**Rezoning Transportation Analysis**  
**Petition Number: Insert Zoning Petition #2022-031**  
*General Location Identifier: 19310302*

**Revision Log:**

Date	Description
07-26-22	First Review (TM)

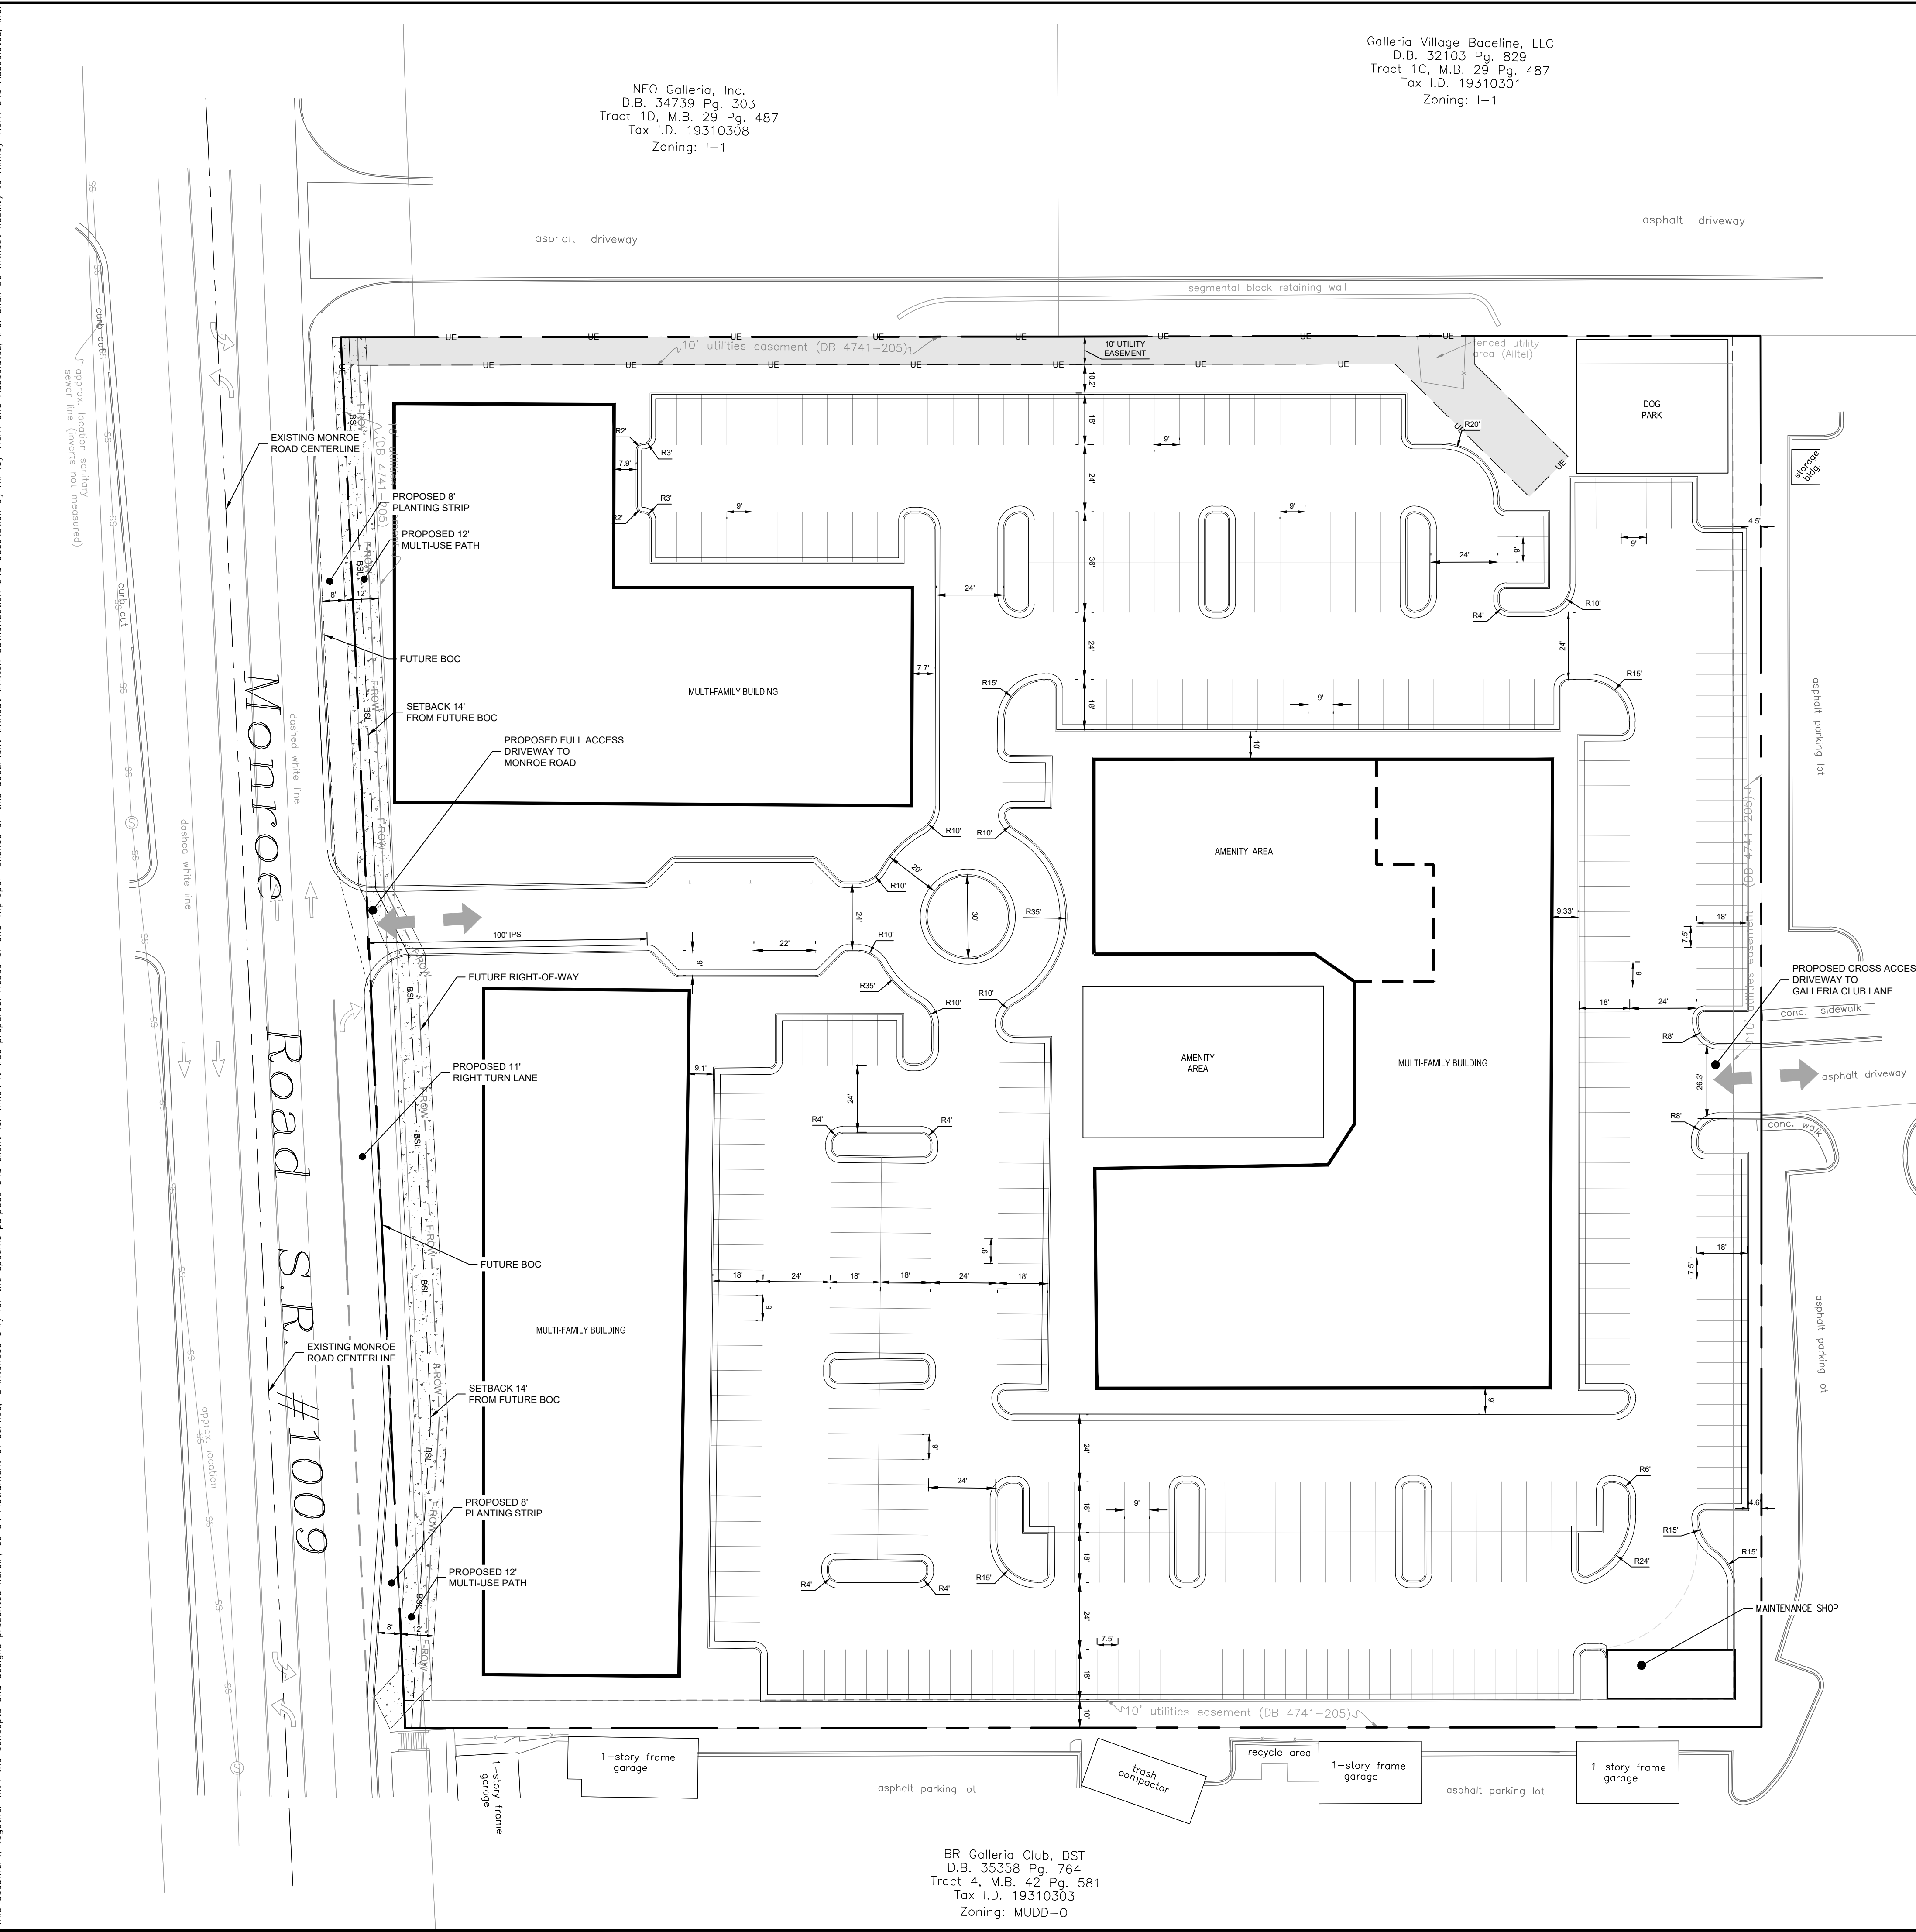
Label and dimension the curb and gutter from the centerline for each road on the site plan.

3. Site plan and conditional note(s) revisions are needed to provide a minimum of 100-feet of protected internal driveway stem at the proposed site access. The protected stem length should be dimensioned from the right-of-way on Monroe Road.
4. Site plan and conditional note(s) revisions are needed to commit to installing a right-turn lane on Monroe Road with a minimum of 100-feet of storage per NCDOT coordination. Label and dimension right-turn lane on site plan and add conditional note describing all turn lane design requirements.
5. **CDOT REQUEST:** Revise site plan and conditional note(s) to provide a private street connecting Galleria Club Lane to Monroe Road.

7. Site plan revisions are needed to provide sidewalk utility easement or ROW located 2-feet behind the 12-foot MUP on Monroe Road. Identify the SUE on the site plan.
